Portland

Re: 23/27 and 26/32 Jarita Court – Plan Review Checklist

SHEET TITLE: **THERMAL MOISTURE DETAILS**  
**ISSUED FOR CONSTRUCTION**

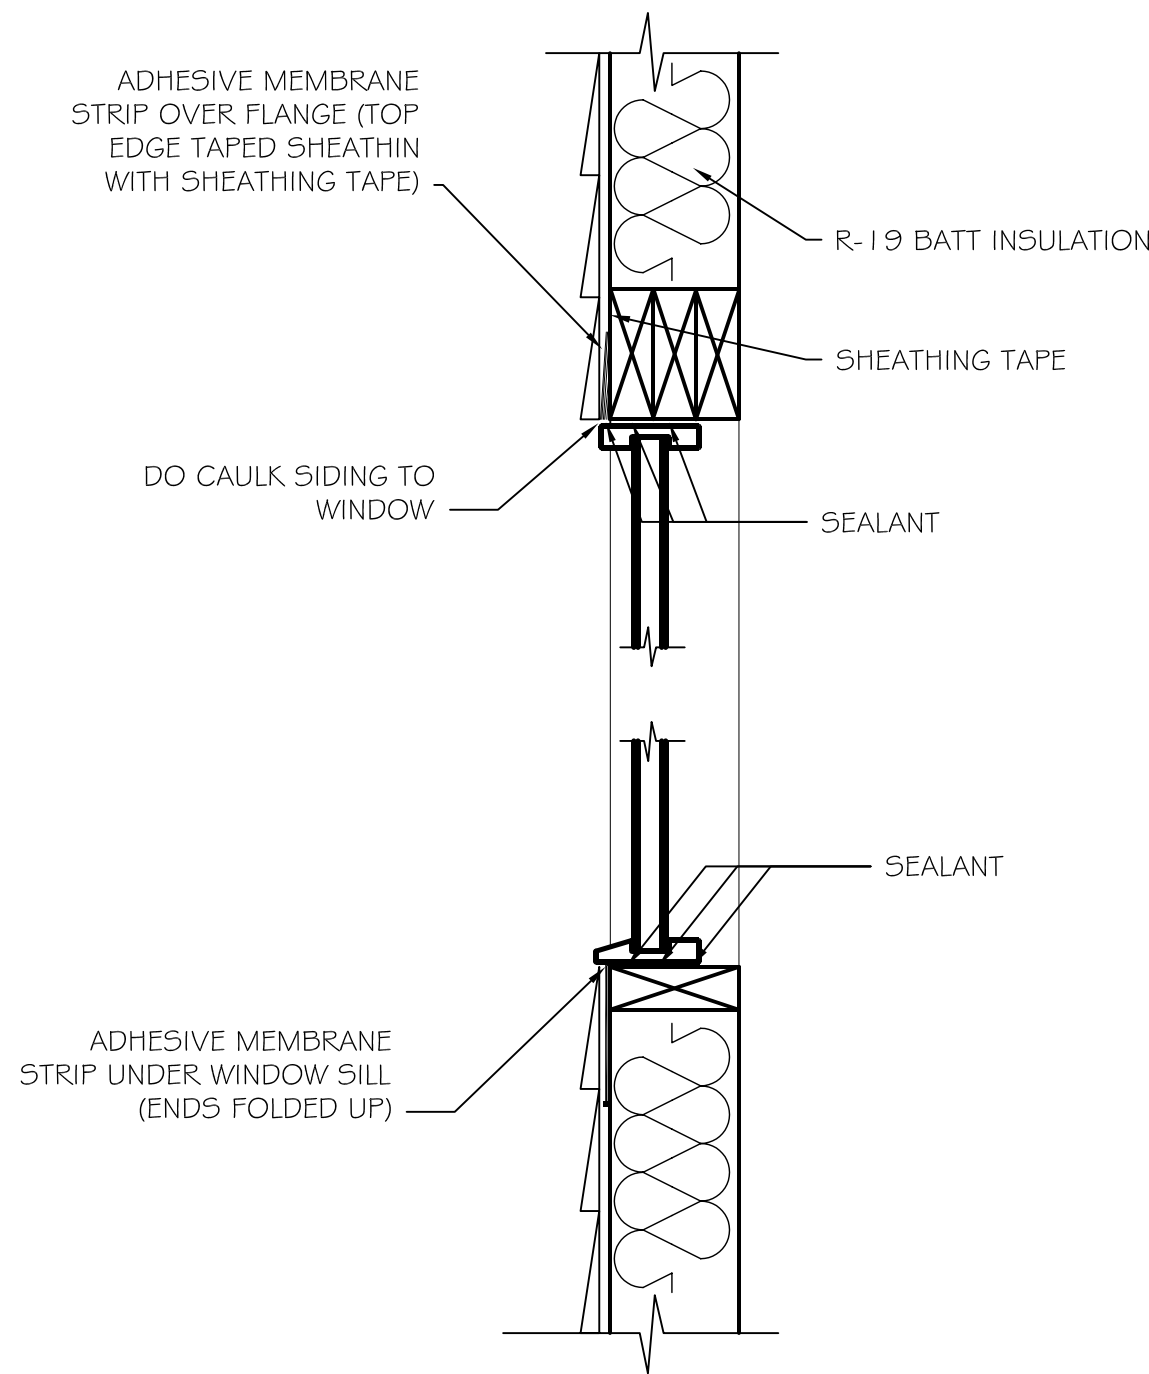
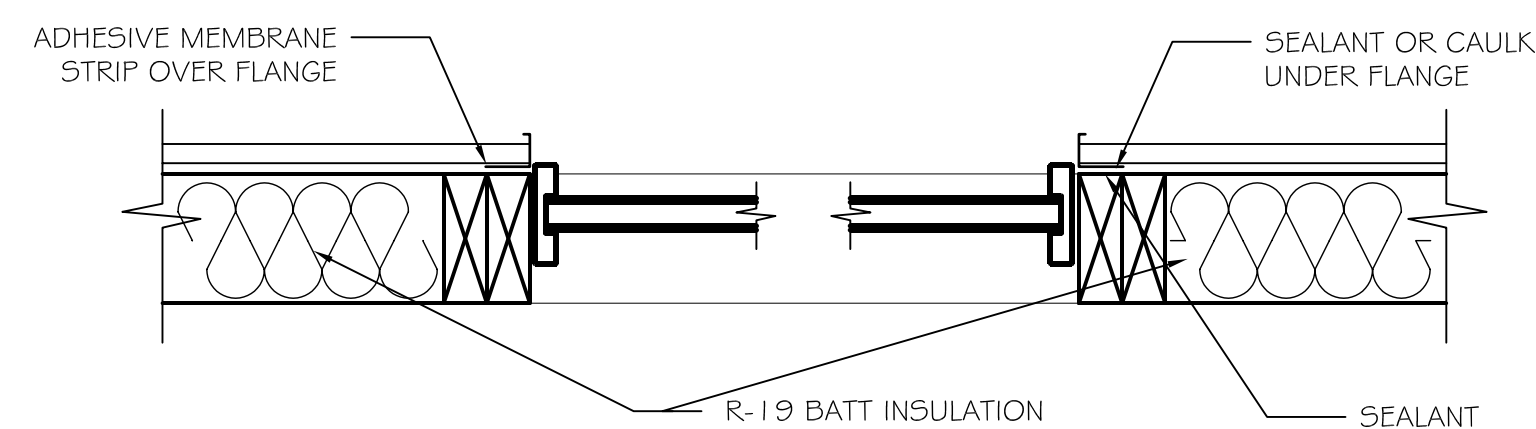
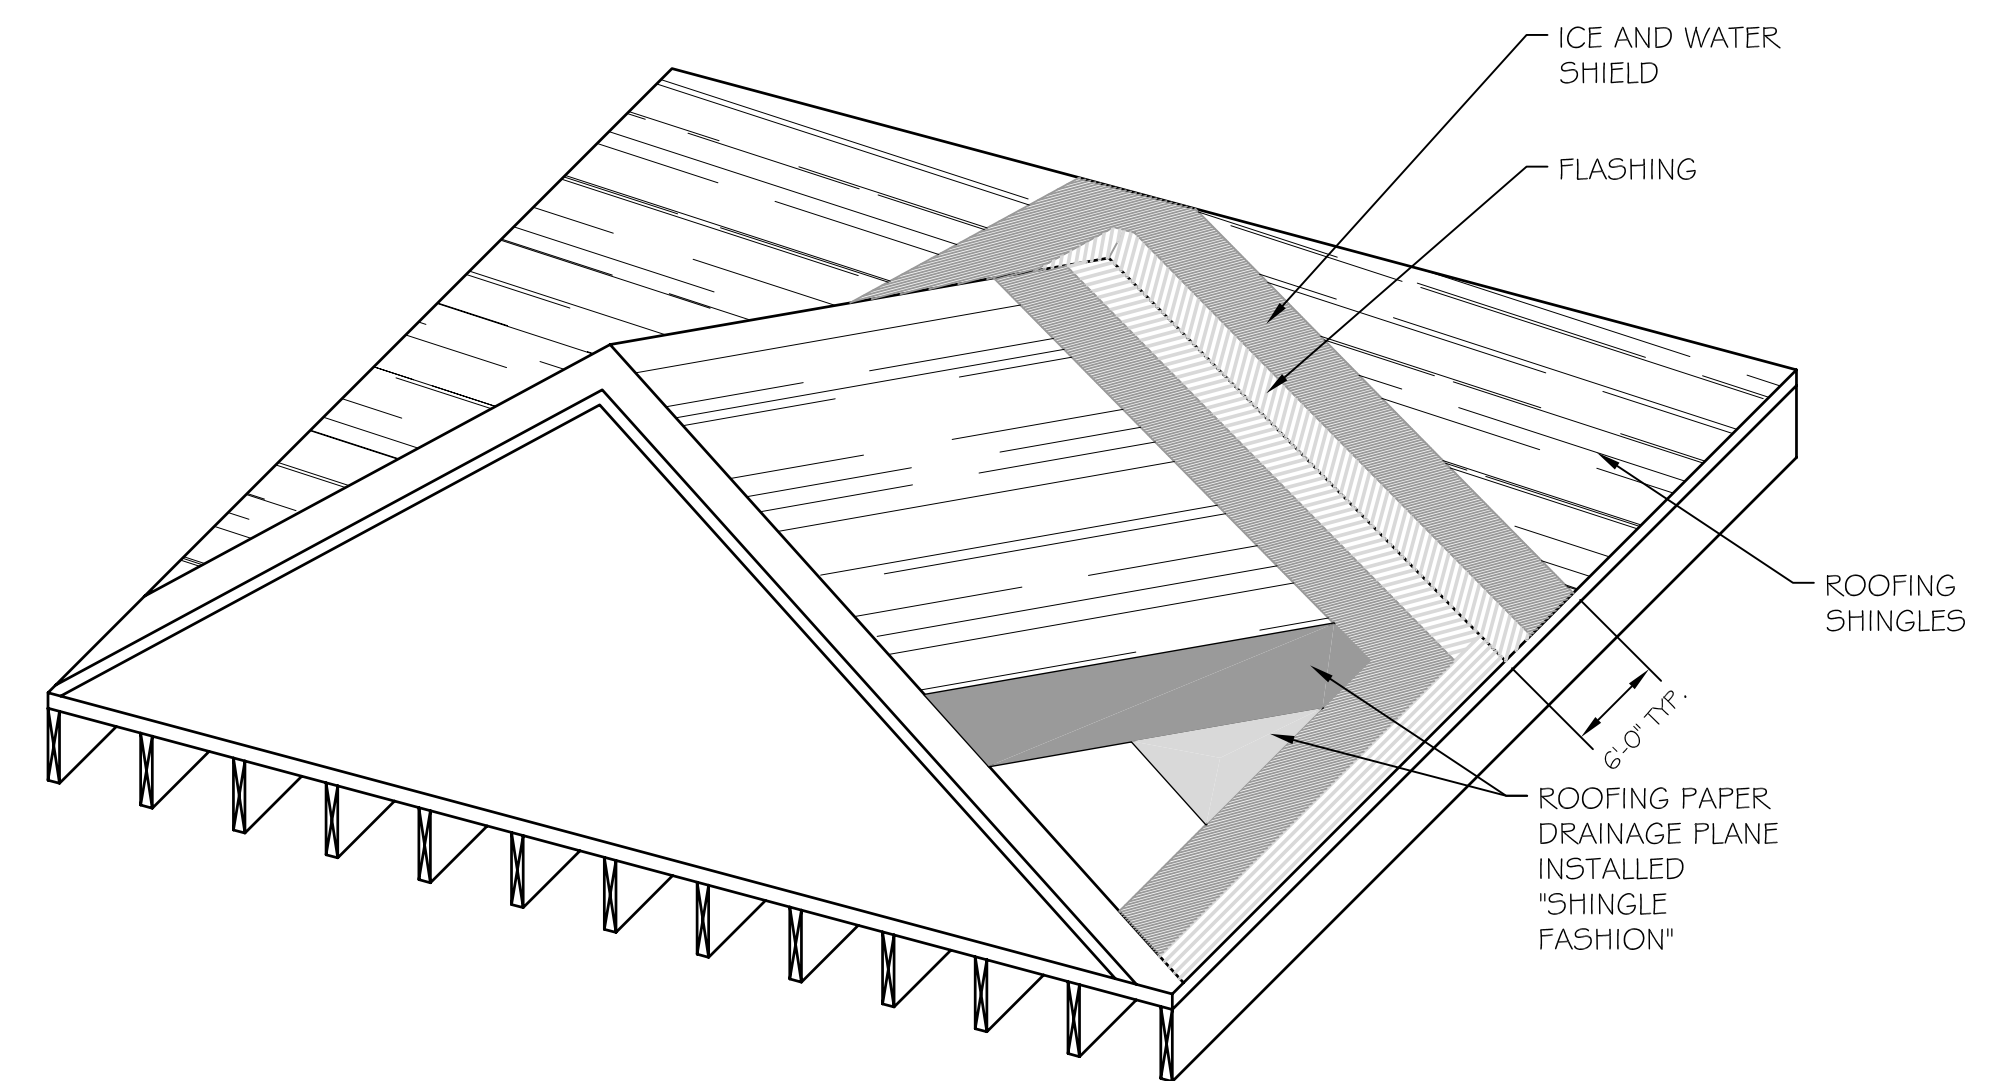
1. Verification of sheetrock under stairs in pantry closet
2. Verification of window manufacturer and egress size
3. Show attic scuttles – minimum of 22” x 30” clear
4. Show minimum headroom requirement in stairways
5. Verification of the garage beam to be 1hr rated as well
